**CITY OF PORTLAND, MAINE  
DEVELOPMENT REVIEW APPLICATION  
PLANNING DEPARTMENT PROCESSING FORM  
DRC Copy**

Capricorn Products  
Project Name/Description

1 - 1 Rice St, Portland, Maine  
Address of Proposed Site  
354 A003001  
Assessor's Reference: Chart-Block-Lot

RE: Change of Use, 1 Rice Street  
ID #2004-0040, CBL #354-A-003

SD-1

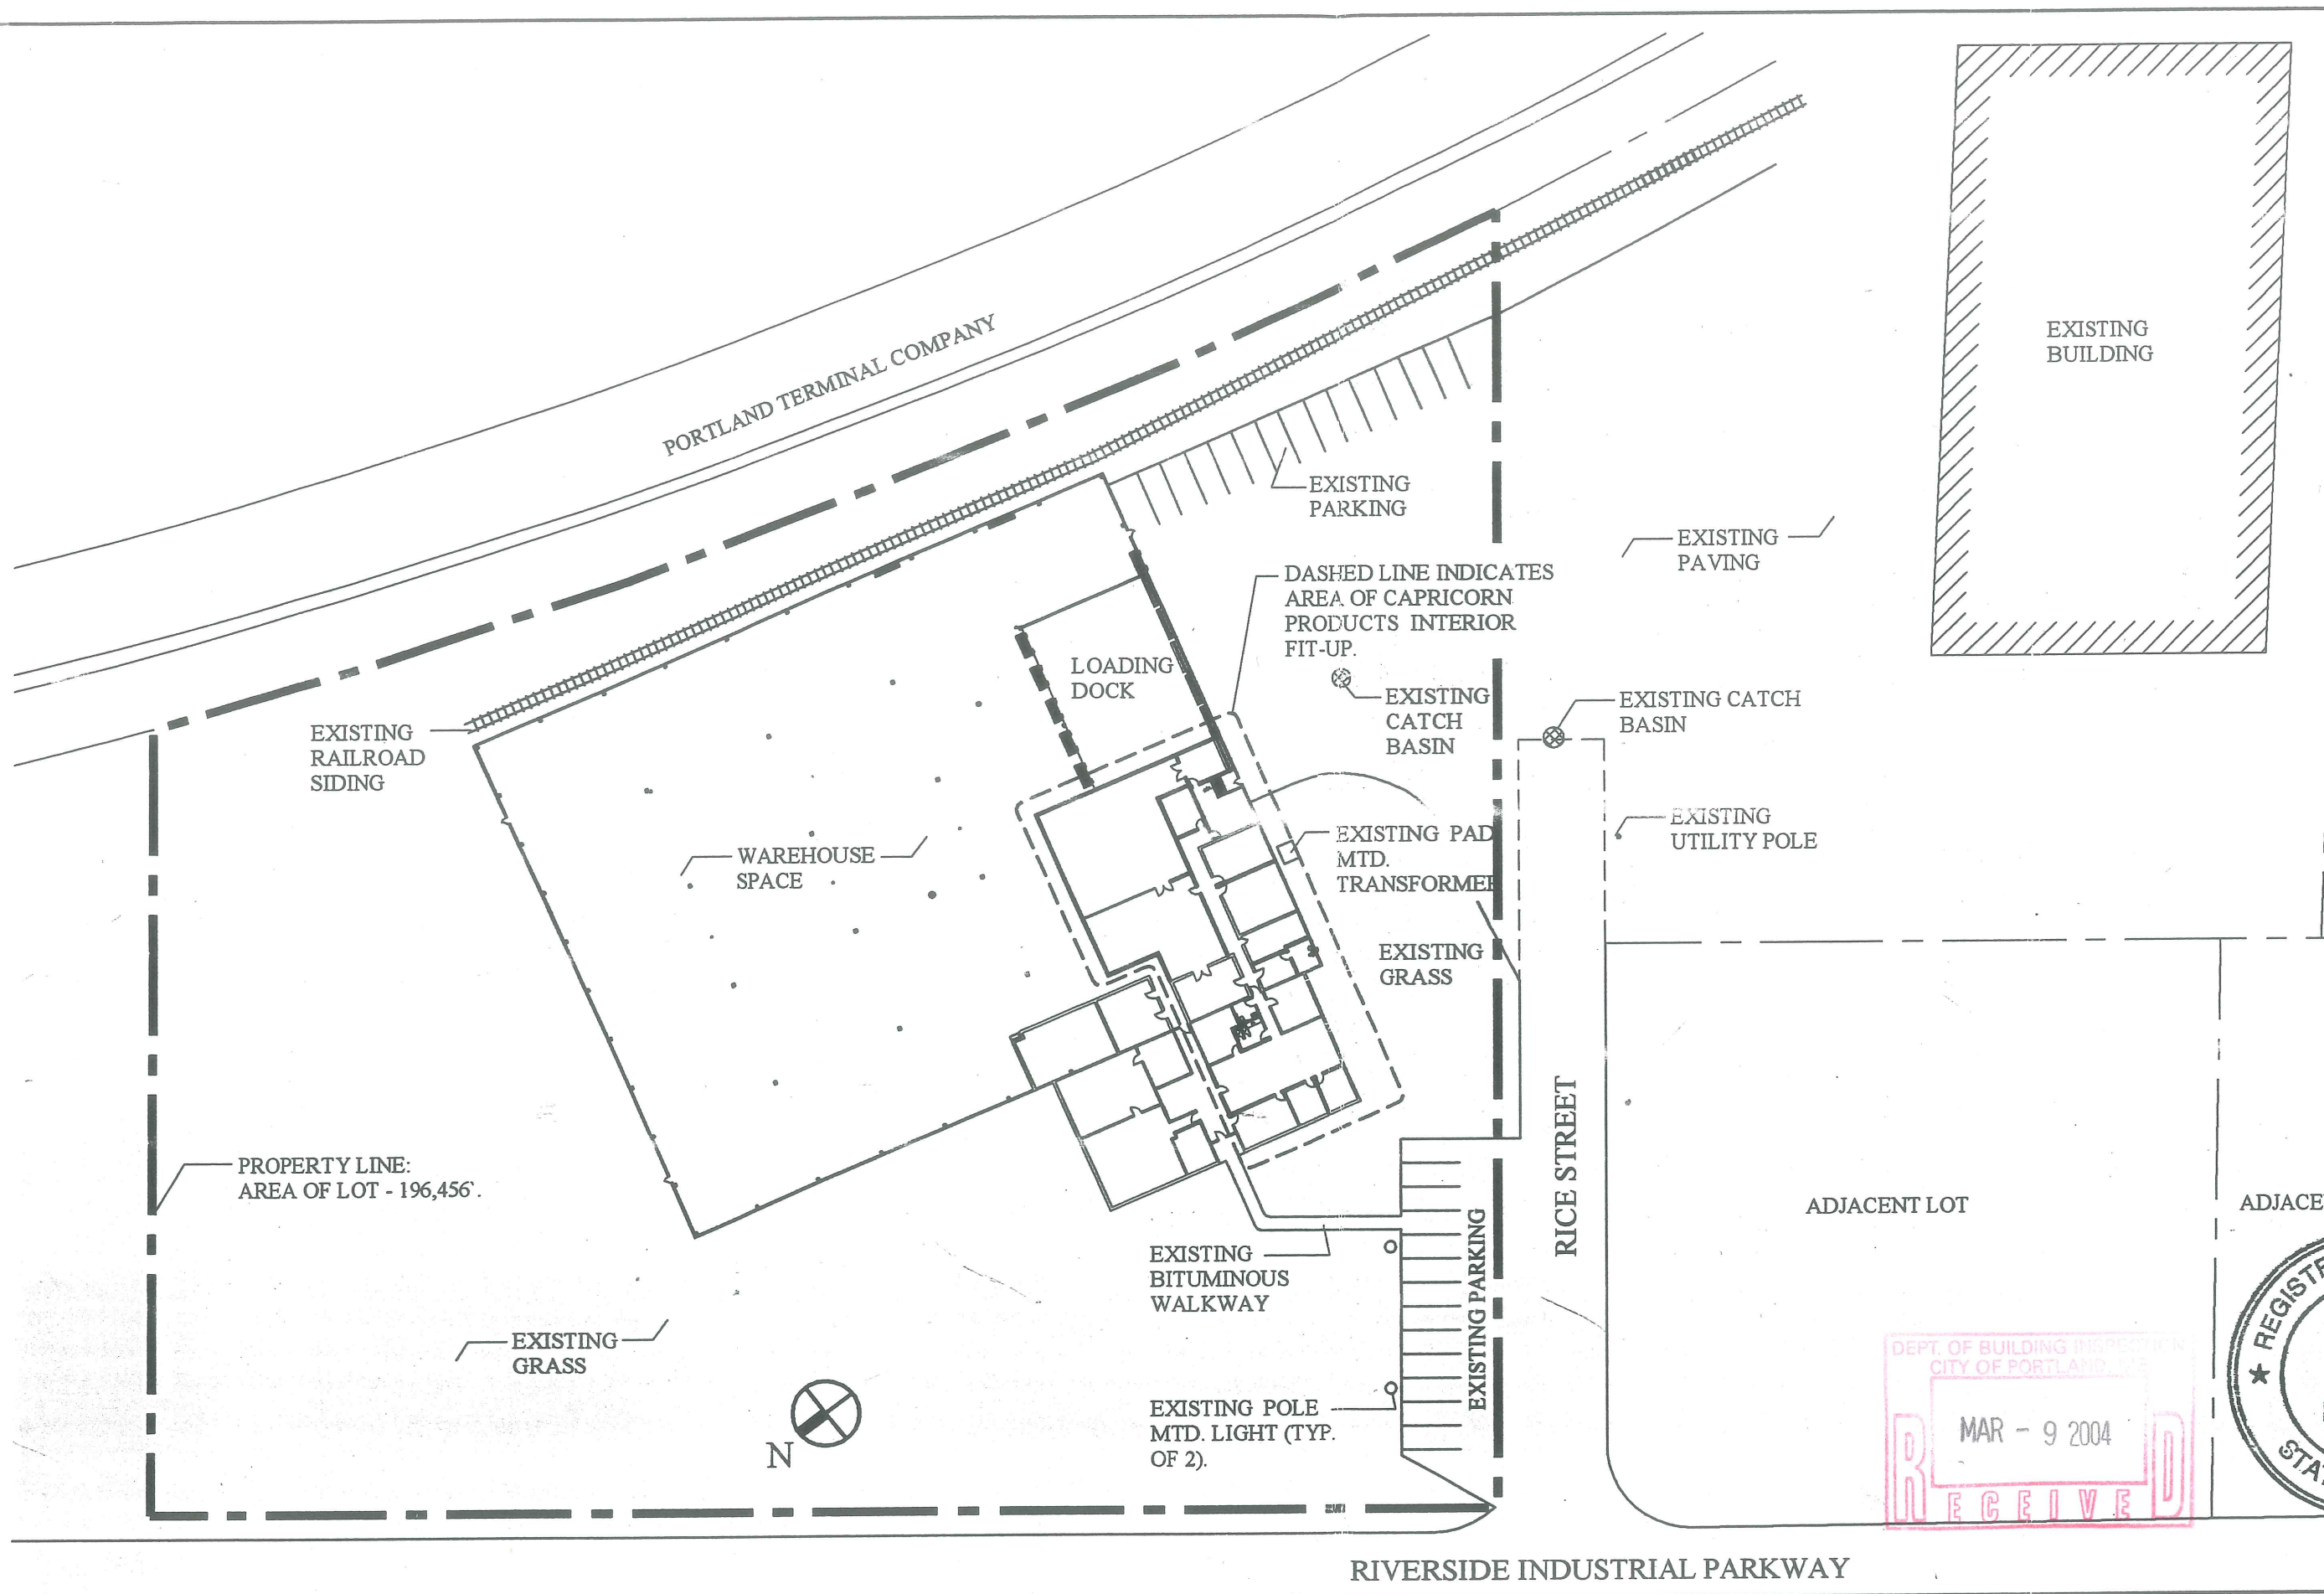
a total of 69 parking spaces are required. I have only counted 27 spaces on the submitted site plan. I have no narrative of uses attached to my site plan application. Was there something else submitted other than a site plan from David Lloyd?

The parking requirement is based on all of the uses in the building, including the past approved industrial warehouse use. Therefore, there are 23 spaces required for the proposed office use, and 46 spaces required for the existing industrial use for a total of 69 parking spaces. The submitted site plan only shows 27 parking spaces, which does not meet the parking requirement.
